RE: Afreya's Playground
12082 NC 42
Fuquay Varina, NC 27526

A plan review was received by this office concerning the construction of the above referenced facility. The plans and specifications are approved with the following contingencies:

Logan Blackmon, REHS I
Environmental Health Section
Harnett County Health Department

AFREYA'S PLAYGROUND
12082 NC HWY. 42, FUQUAY VARINA, NC 27526
PLUMBING WATER PLAN

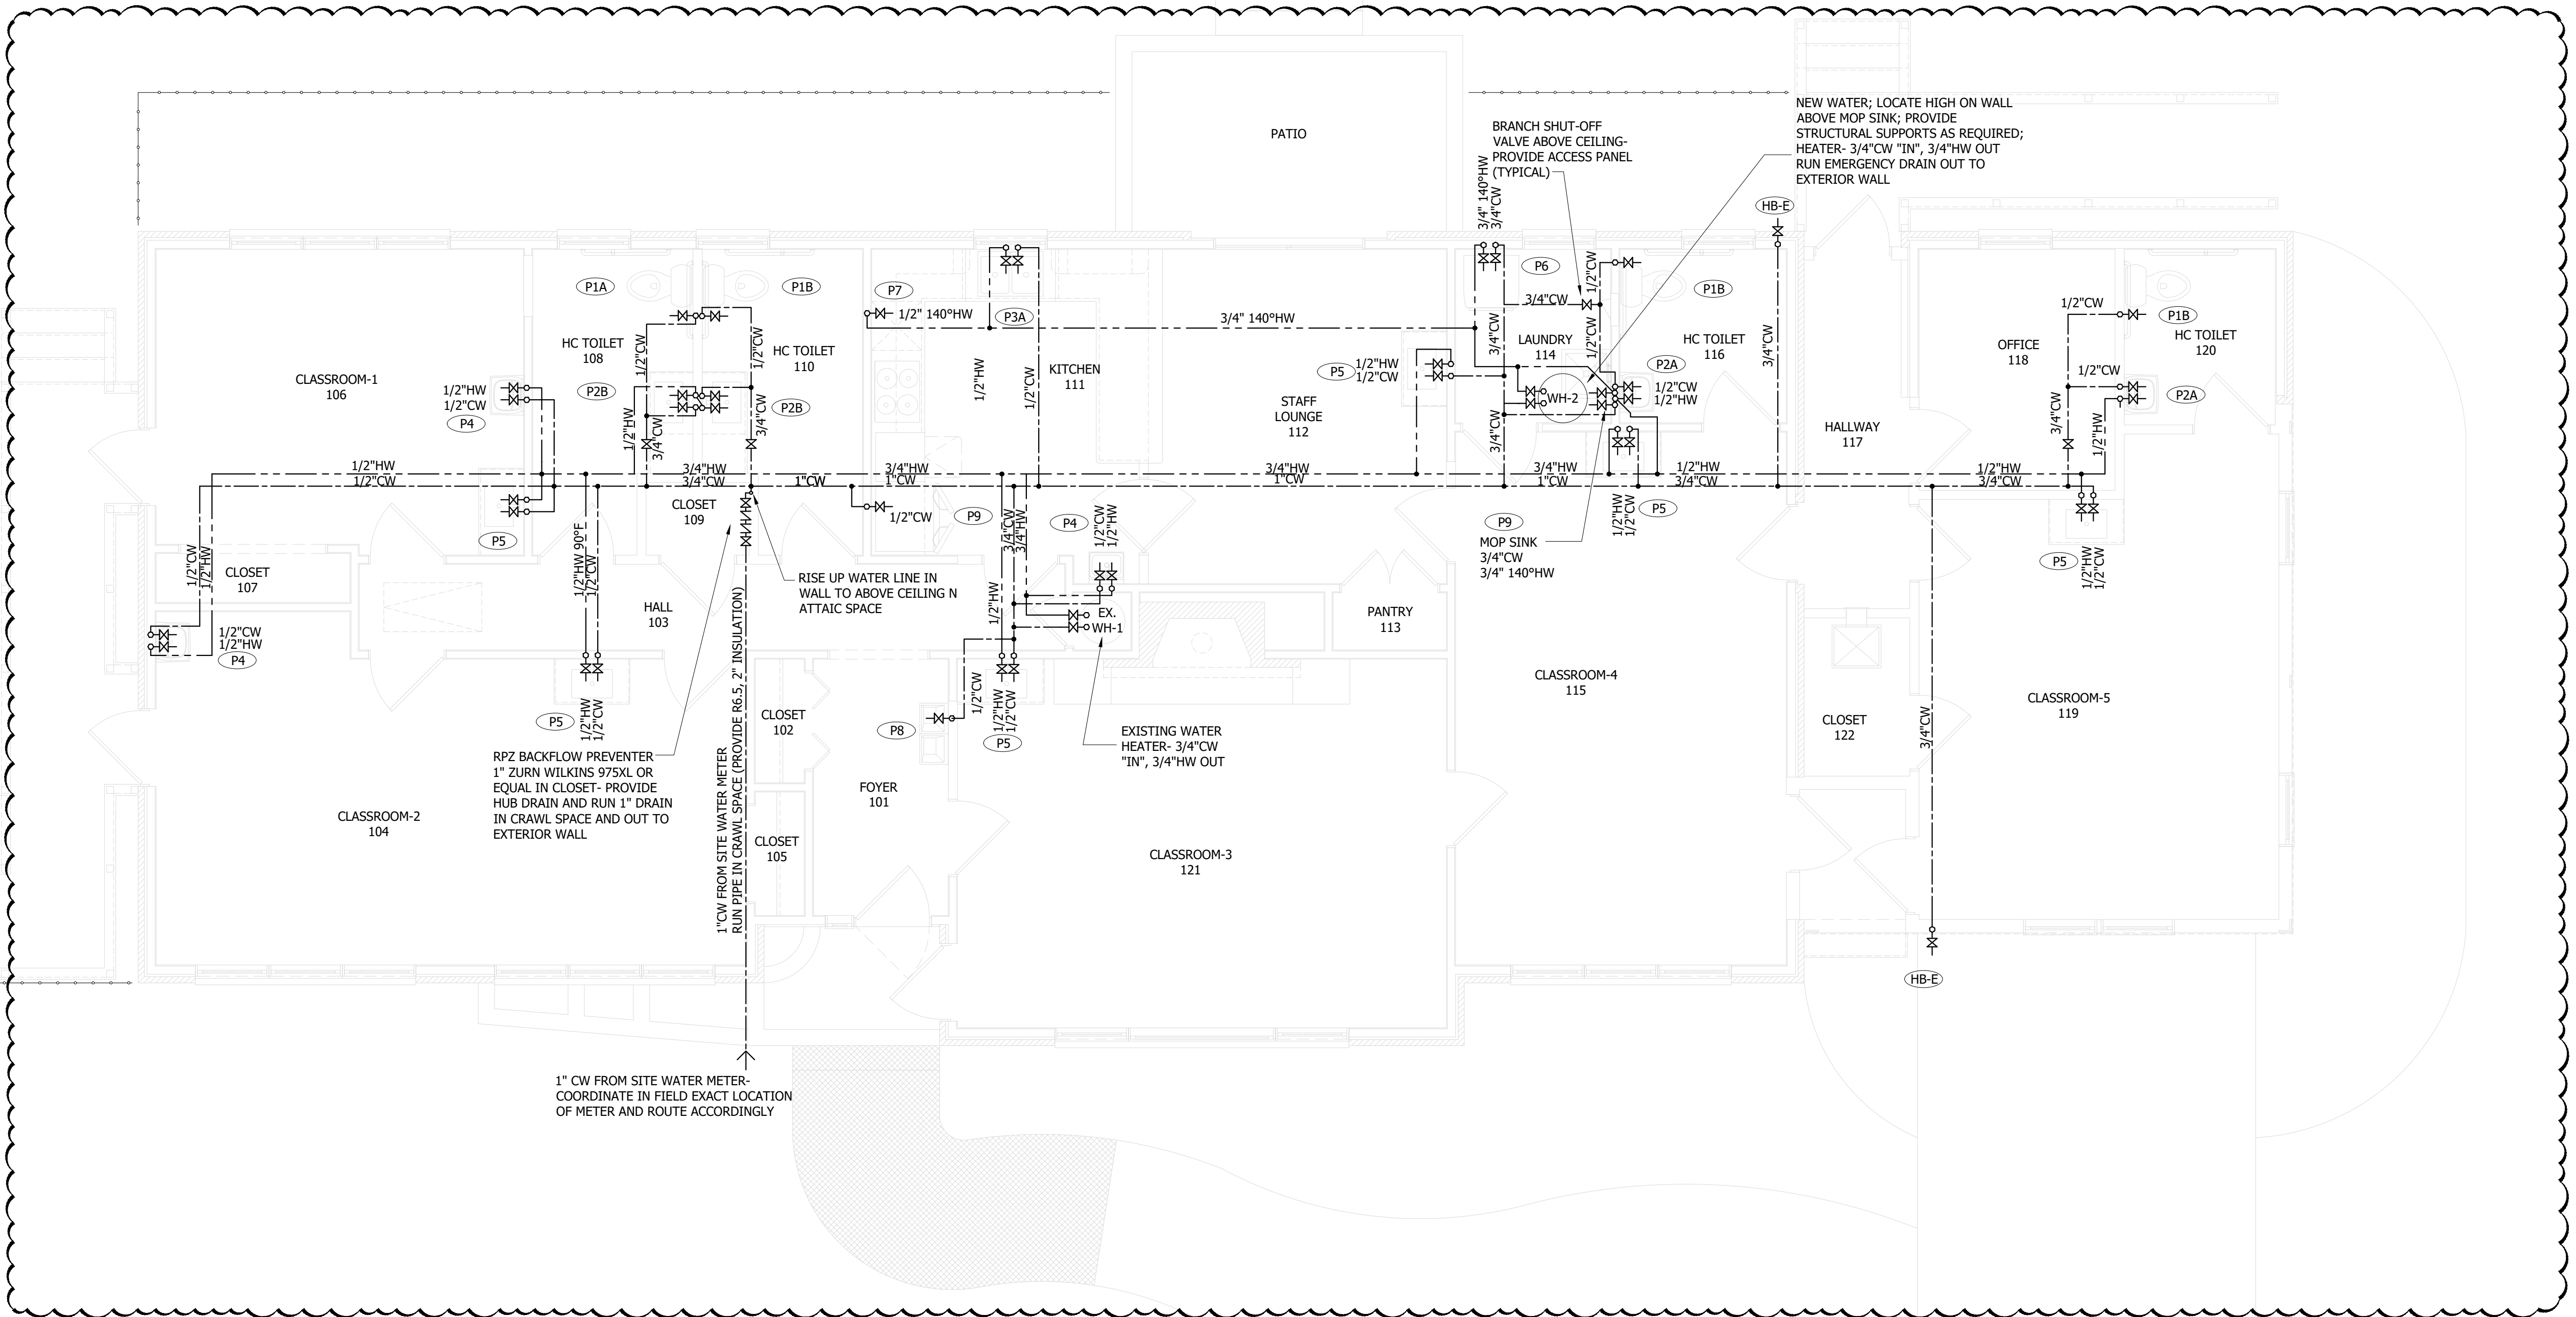
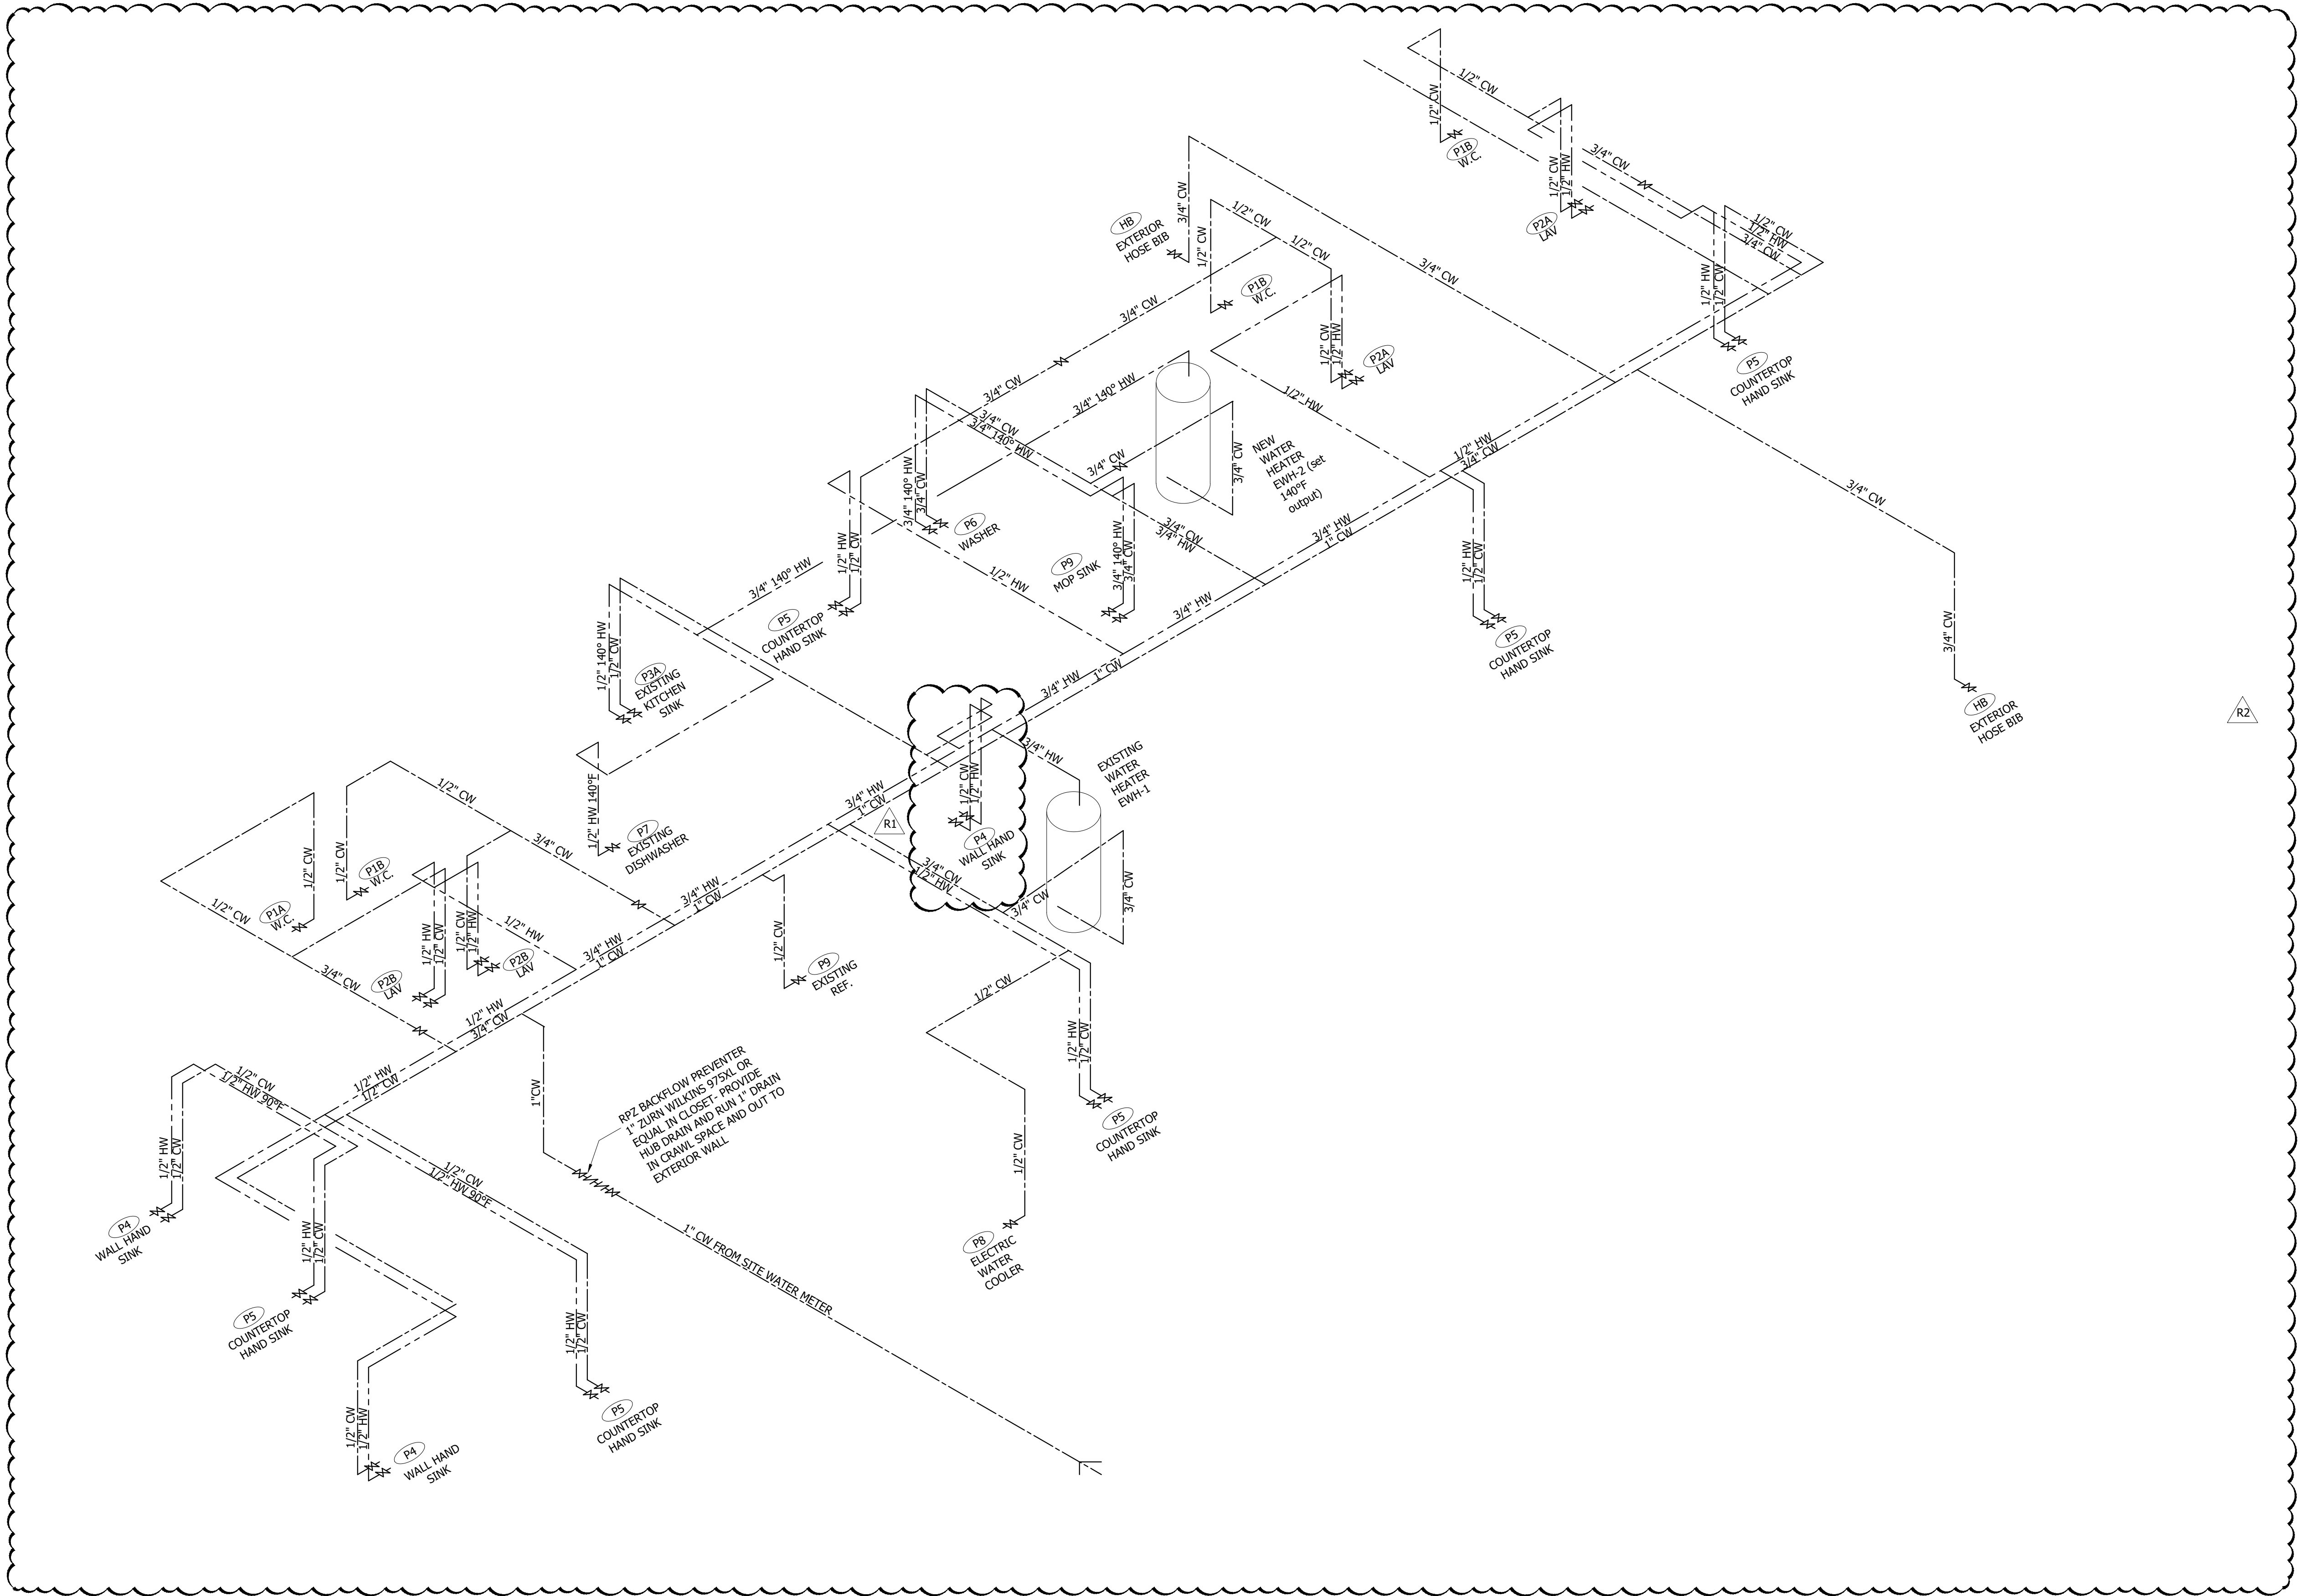
- 1: Classroom 3 is not approved for diapering due to the presence of a single hand sink in the classroom. Each diaper changing station shall include a handwash sink.
